TO:	Helen Donaldson, Sr. Planner	DATE:	11/8/2018
FROM:	Michael Guethle, PE; Ryan Wingard, PE	PROJECT NO.:	13982C
SUBJECT:	Gilman St. - 22; MMC Parking Building (PL-000331-2018)

Wright-Pierce has reviewed the Level III Site Plan Application information provided for the Congress Street Patient Care Building proposed at 22 Gilman Street. The project will include redeveloping an existing parking garage into 64 modern patient rooms and 19 procedure rooms.

12/17/2018
C11-01

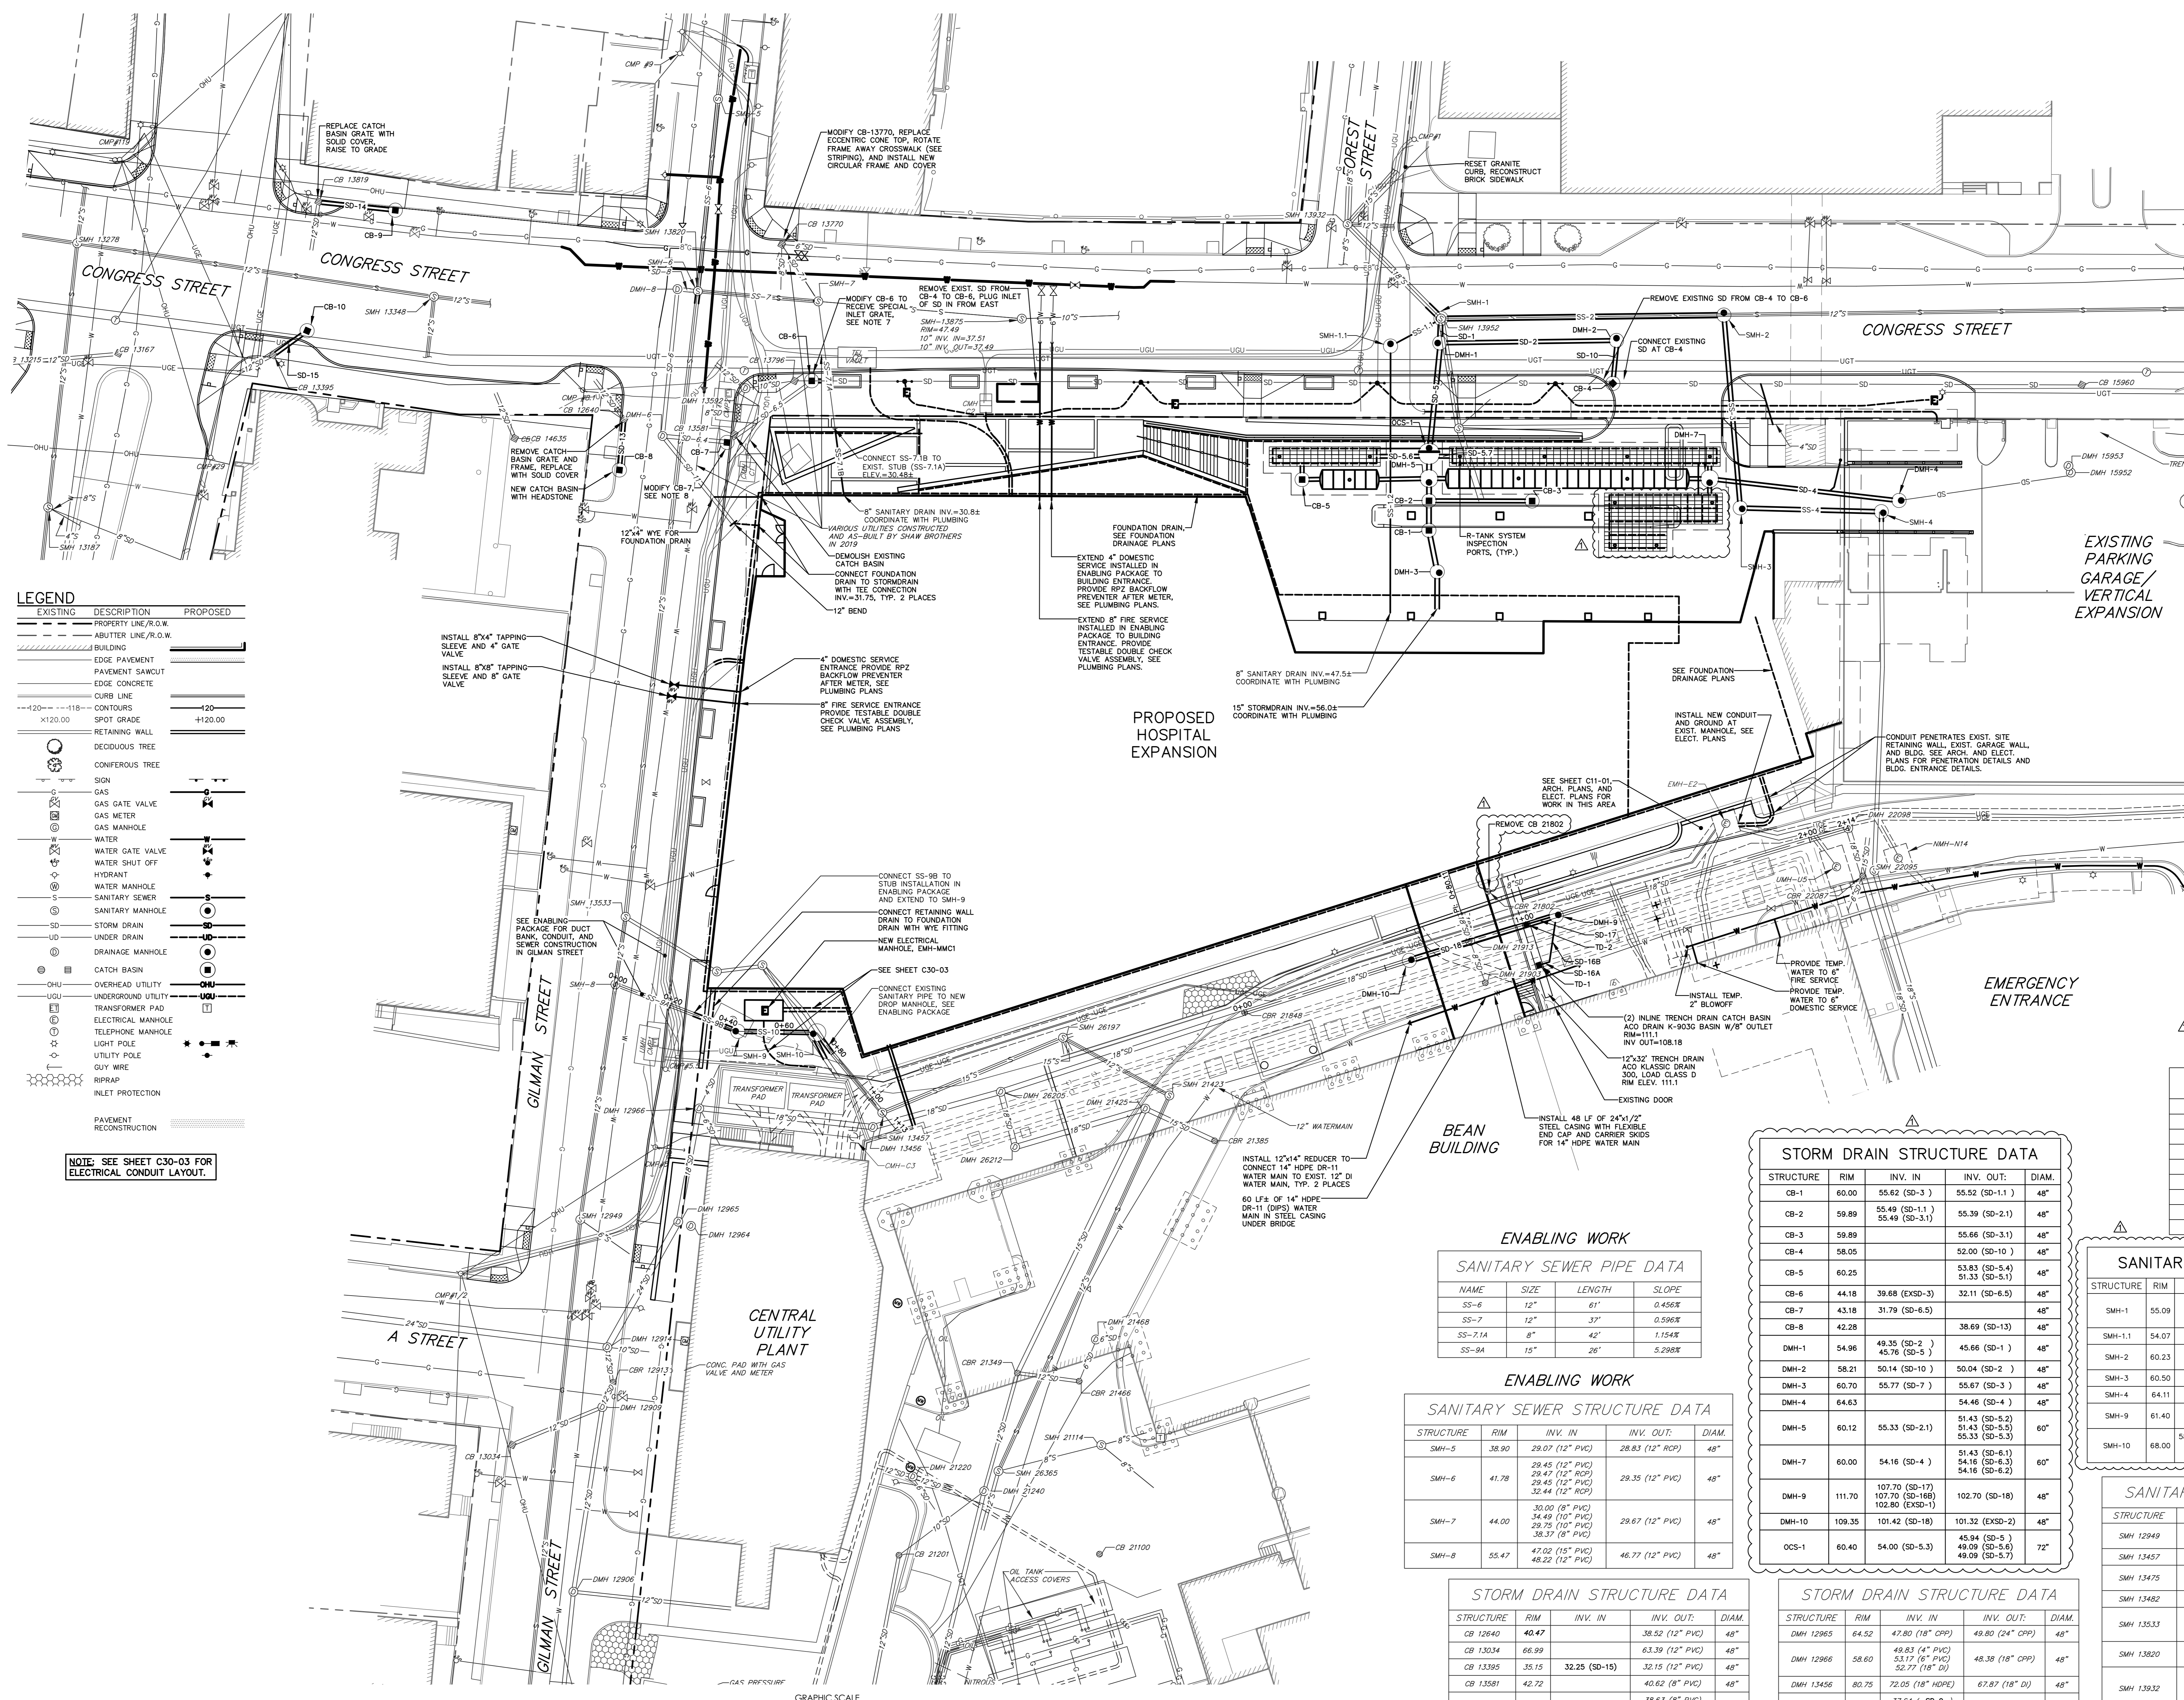
- 4) Proposed Drainage Design
- a. Additional information has been provided on Sheet C30-01, C11-01, C40-01, and C30-04 to indicate site grading and pipe information. The following shall be clarified:

- i. SD-2 References two different pipes. Please clarify.
 - ii. SD-3 is a 12-inch pipe that accepts flow from a 15" pipe and conveys flow to a 15" pipe. Please revise or indicate the need for this size change.

- iii. Several of the slopes indicated in the "STORM DRAIN PIPE DATA" table do not match the slopes calculated from the invert and length data indicated in the "STORM DRAIN STRUCTURE DATA" table. Please revise.

- b. Sewer Infrastructure
 - i. Sewer manhole, steps, frame and cover details, as well as pipe slopes, have been included on Sheet C11-01 and C30-03. Pipe design and slopes and in accordance with the City of Portland Technical Manual.

SHEET NUMBER
C04-01

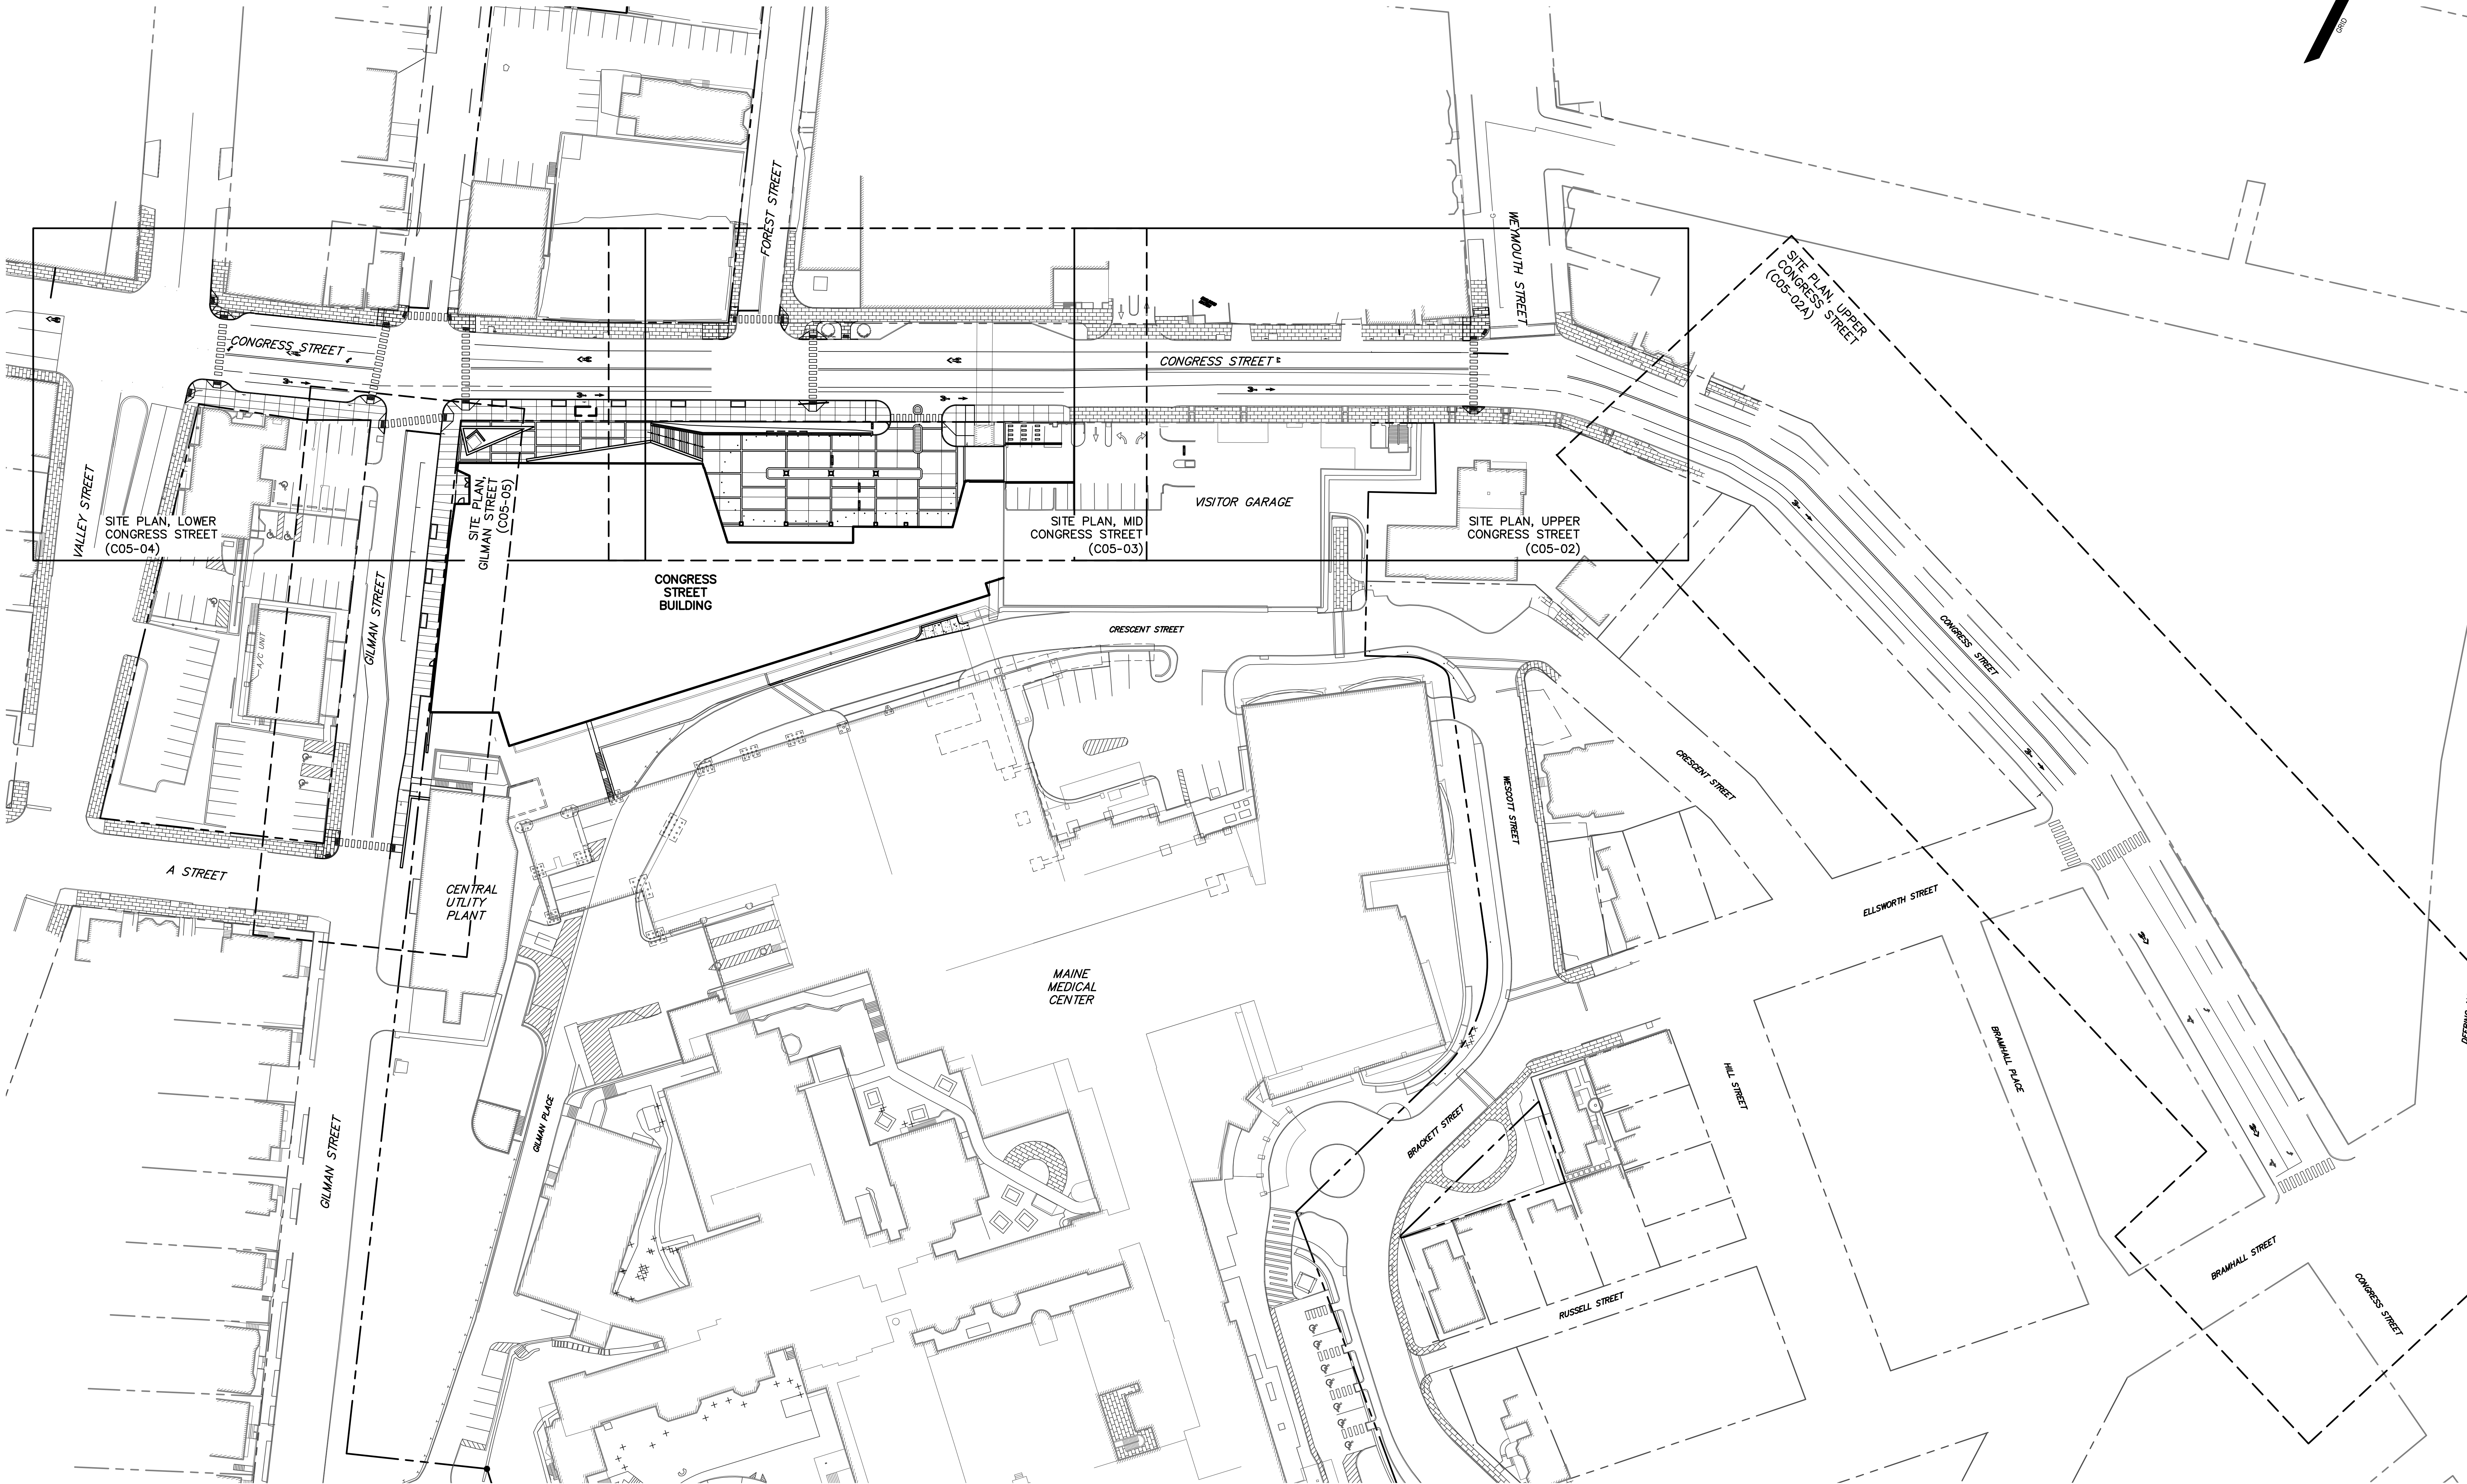
- ii. Location of Erosion and Sedimentation Control best practices have been indicated on Sheet C04-01. This item has been reviewed and accepted.

- ii. A transformer is scheduled to be removed on the Demolition Plan under item U-4. Please confirm if the transformer is to be relocated, as well as the location of any new transformer. Above-ground utility infrastructure shall be sited and screened in accordance with City standards.
